From: Katie Kurek [REDACTED]
Sent: 04 December 2017 11:58
To: Simon Davis
Subject: RE: Planning Services Response Re-consultation EG/69/17

Further to your response below, we have a parish council objection stating: "The council considers that the application should not be permitted without an allocation of space, on site, for articulated and other vehicles to turn. A condition requiring the use of such turning space should, if possible, be added to any permission."

Heather Godmark			
Swallowfield, Eastergate Lane			
Visibility Splays and Swept Path Analysis			
Varies @ A2	SMO	ALB	PMR
October 2017	2016/3448/001		C

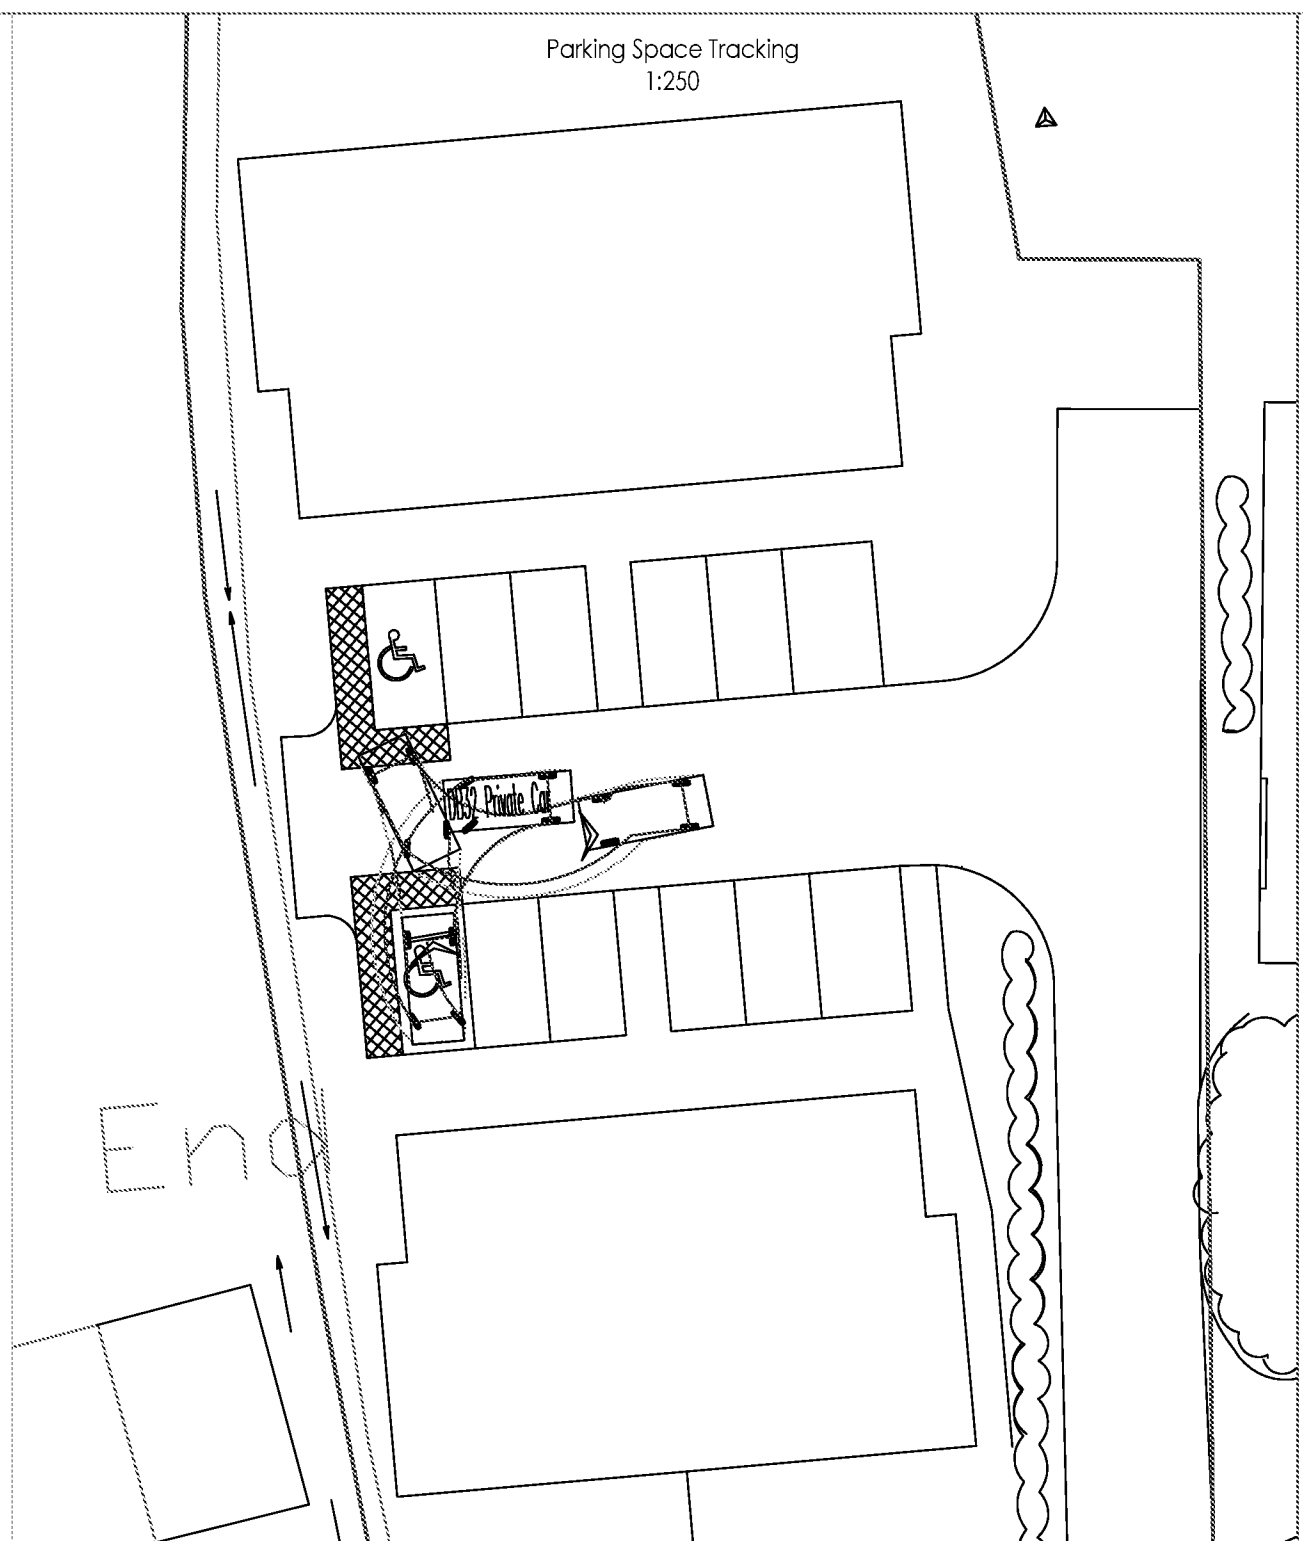
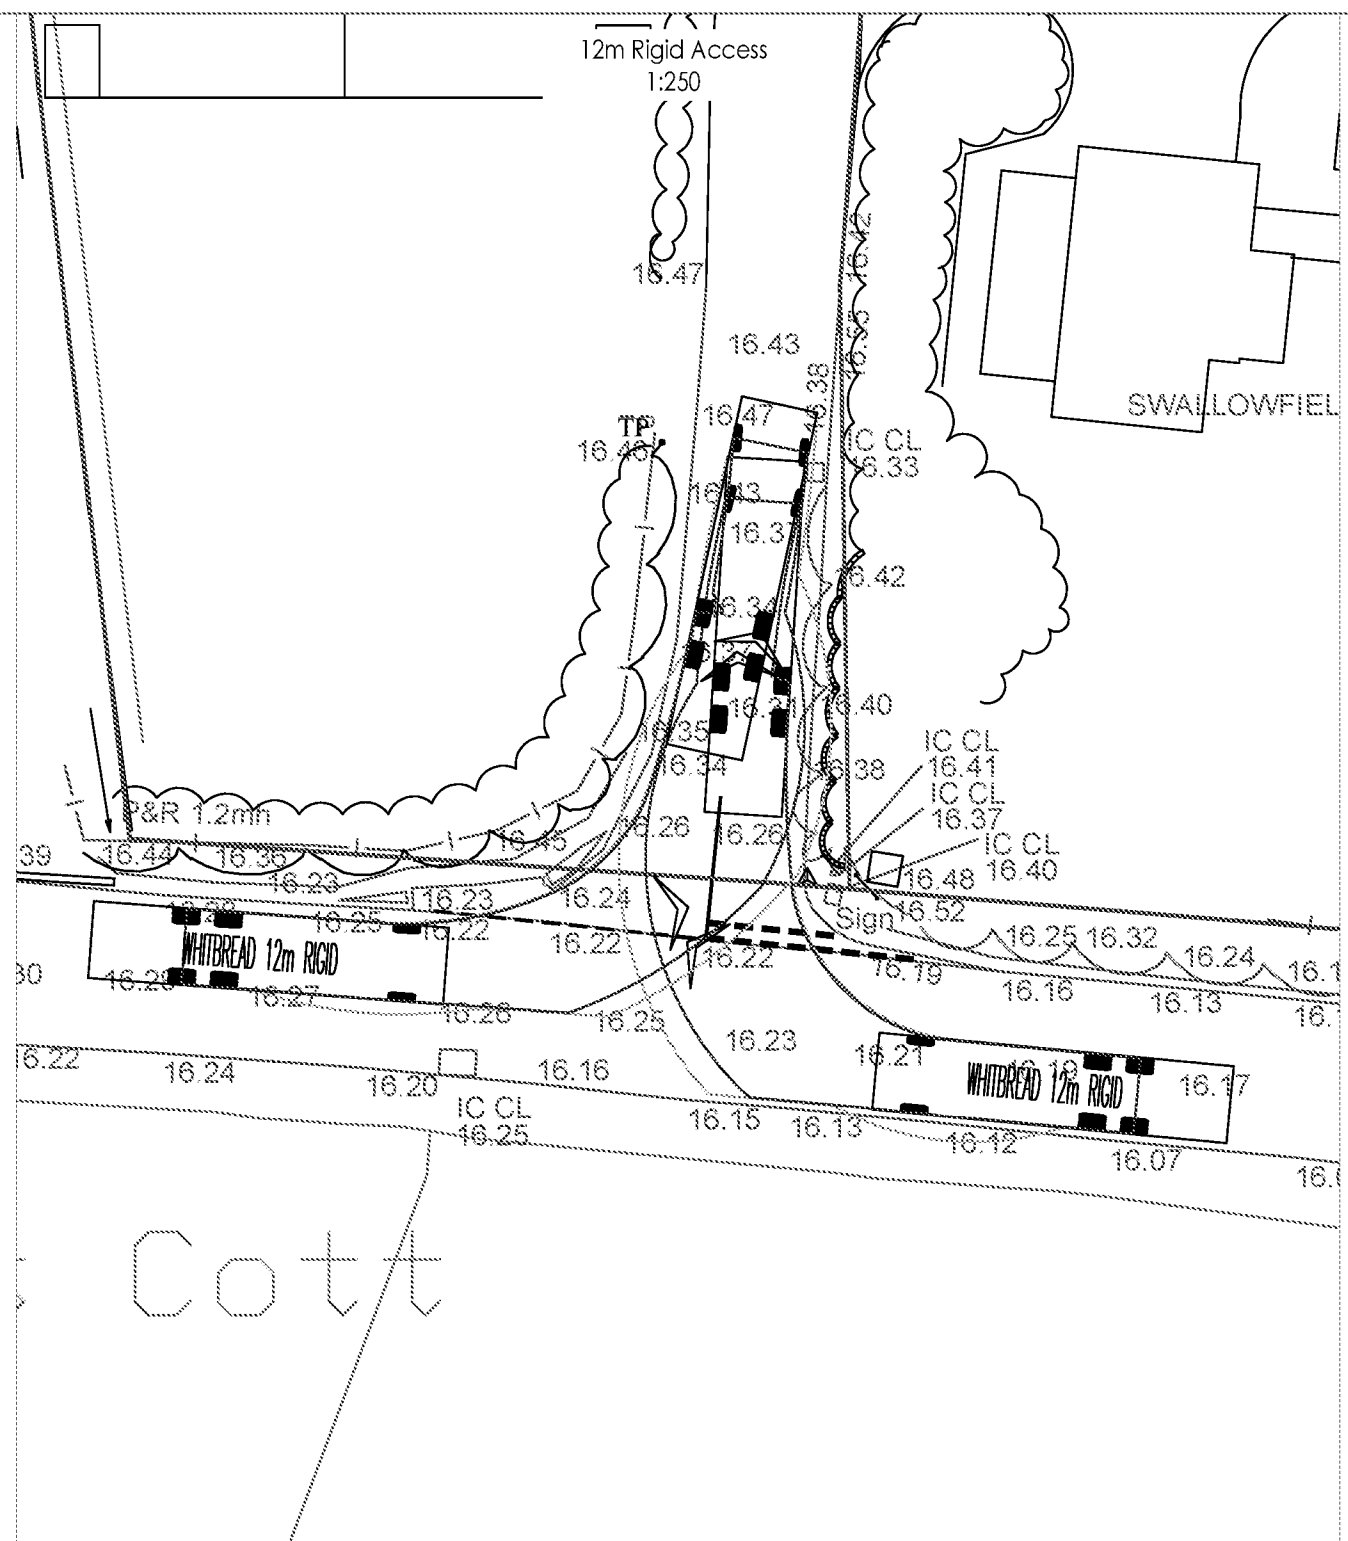
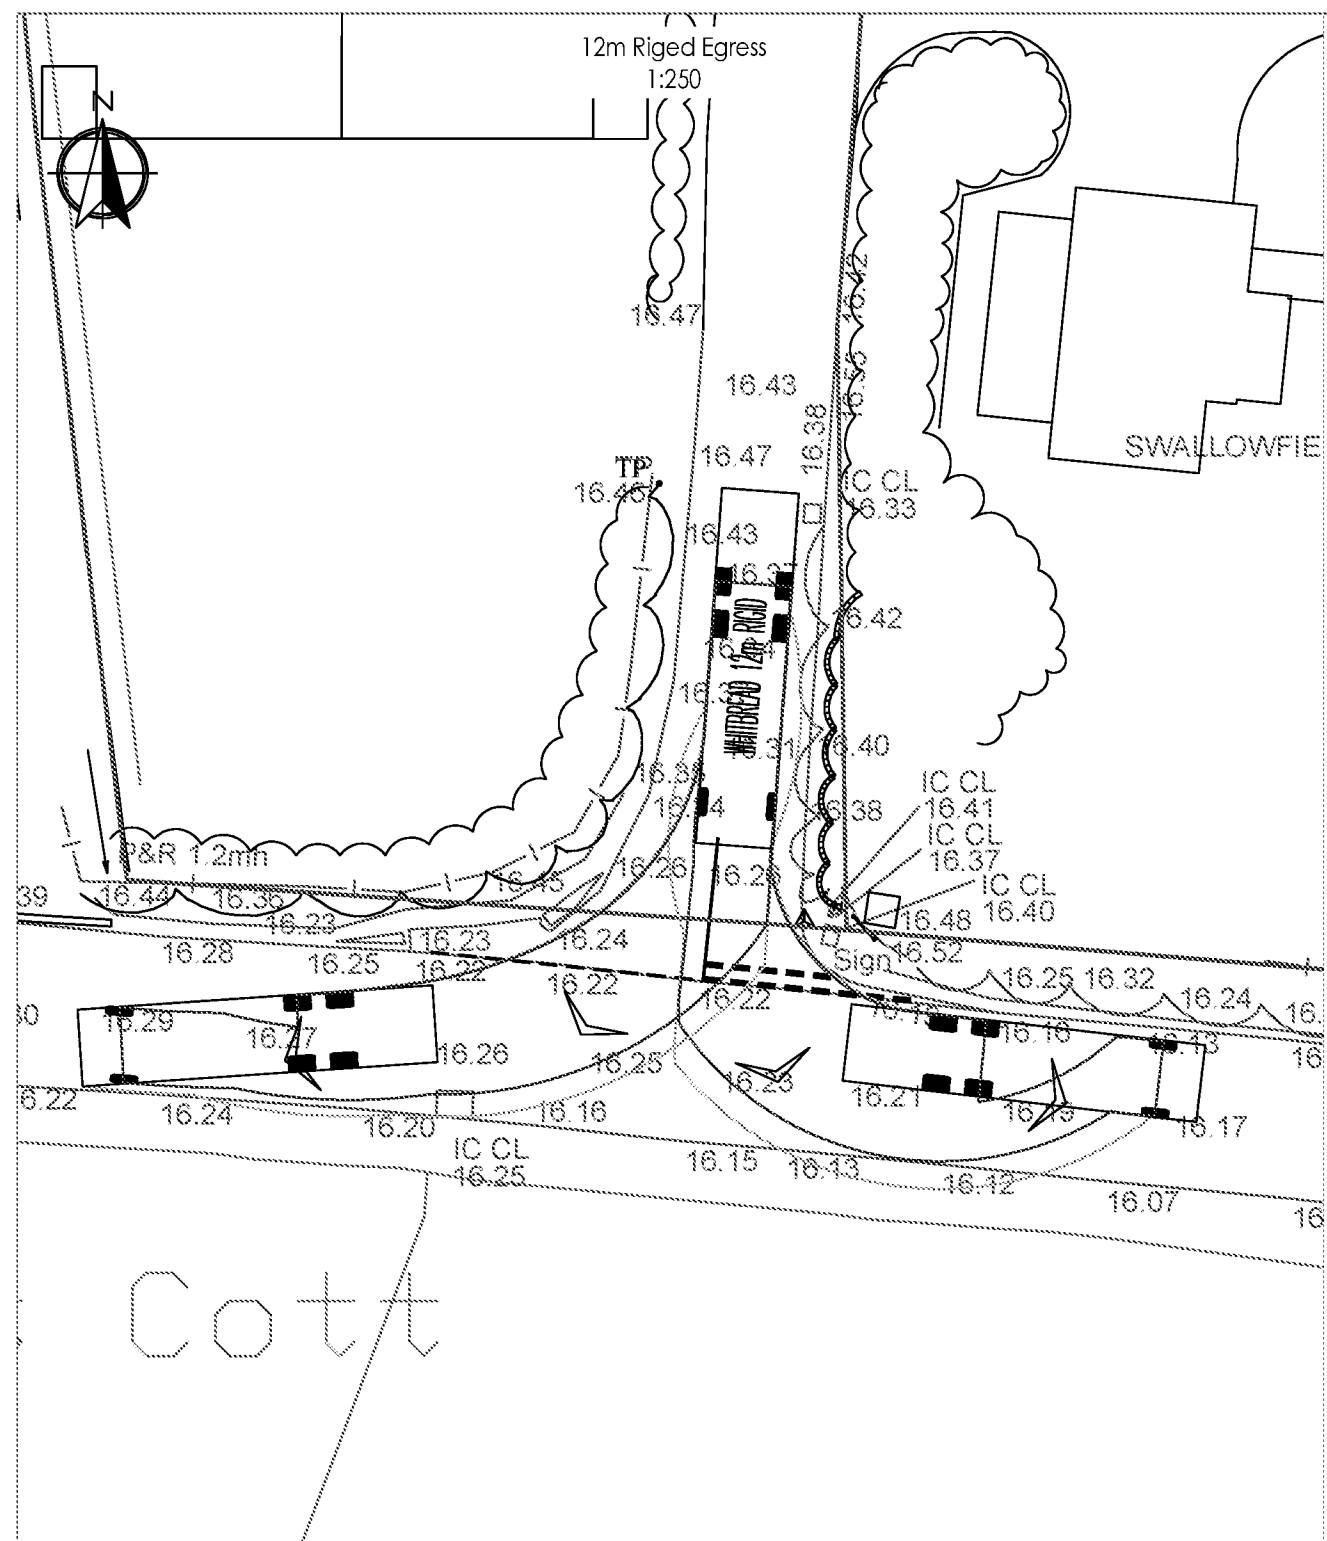
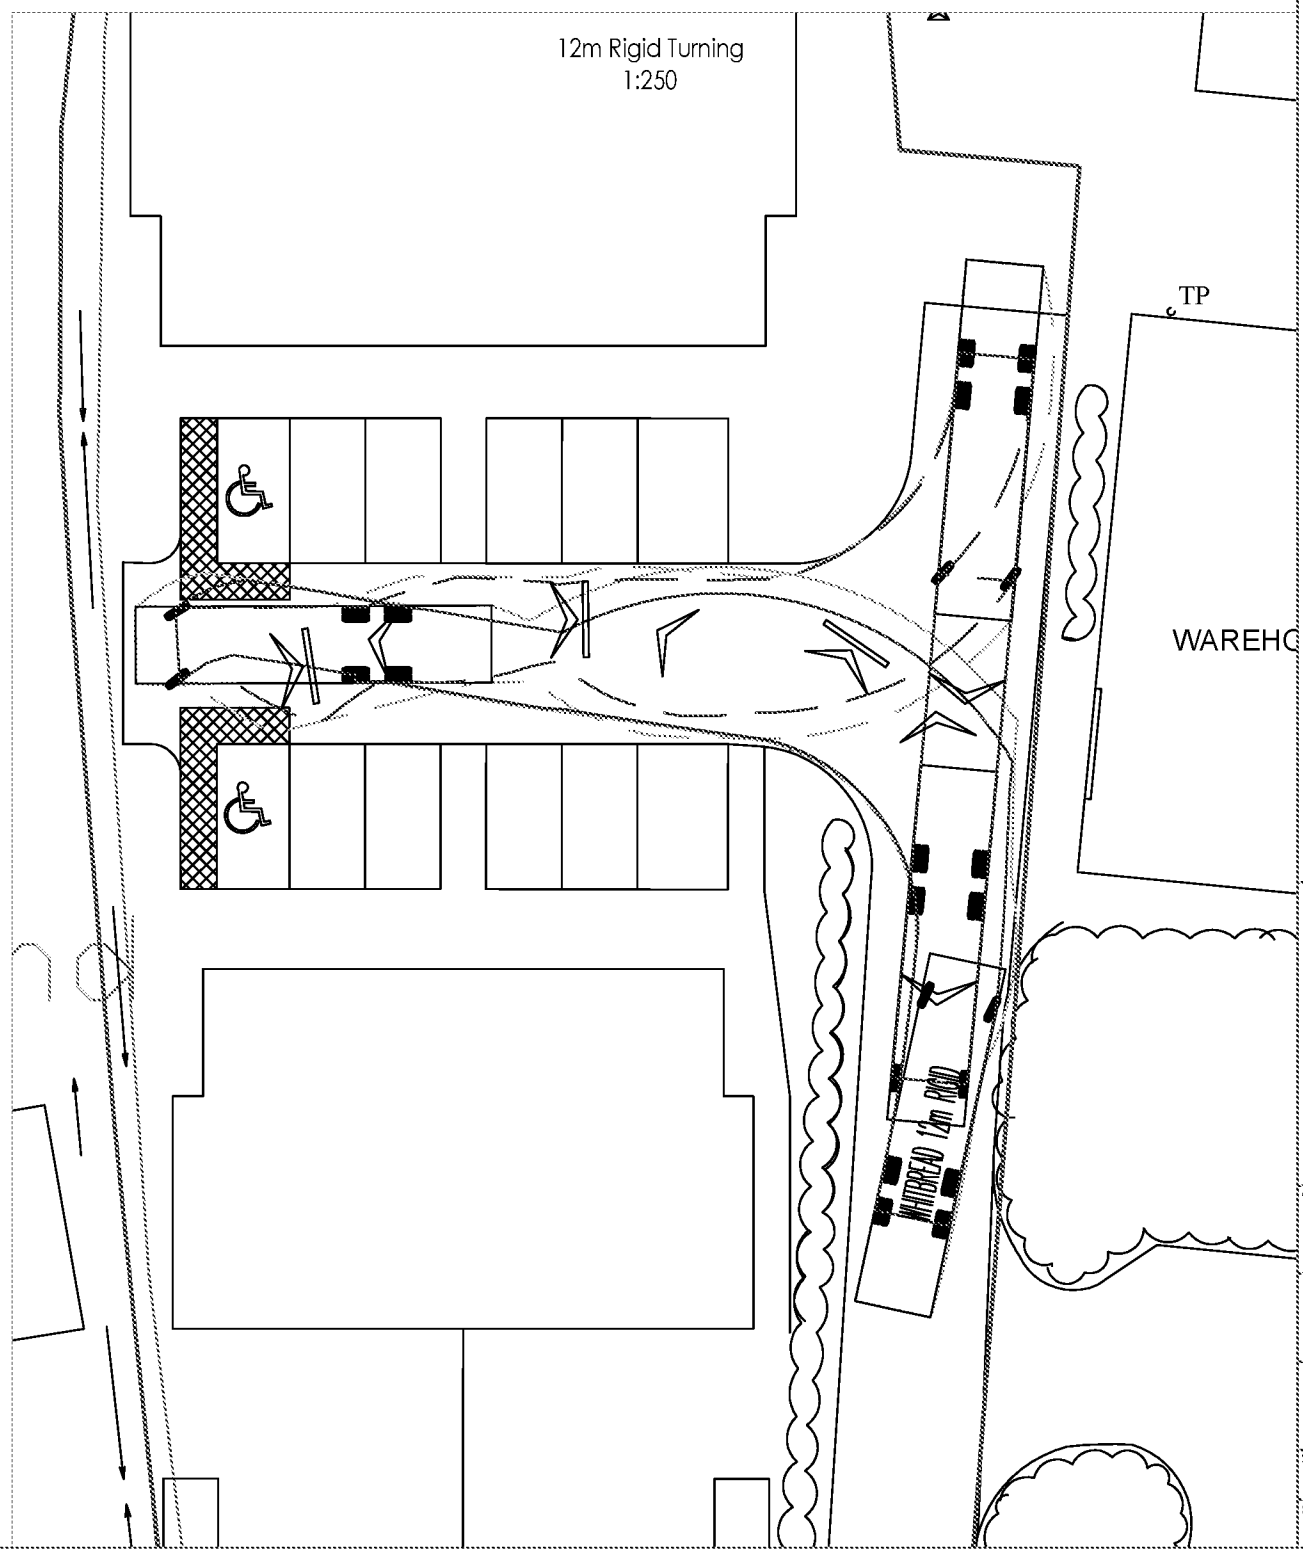
Using our own swept path plans I cannot be 100% sure that an articulated lorry could turn with the live/work unit section of the site because of the limitations of the drawings. However, I am mindful of the existing layout with the greenhouses and that with regard to space available to turn on site this does not appear to be materially different from existing situation. With reduction in greenhouse at the site and proposed use as live/ work light industrial units I would question the need for an articulated lorry to serve the site. It may be worth asking the applicant if and how this occurred on the site as existing and whether these type of vehicles are anticipated with the modified use at the site.

Your response states that the turning space on site would be suitable for larger vehicles including refuse collection and fire appliance. Would this include articulated vehicles?
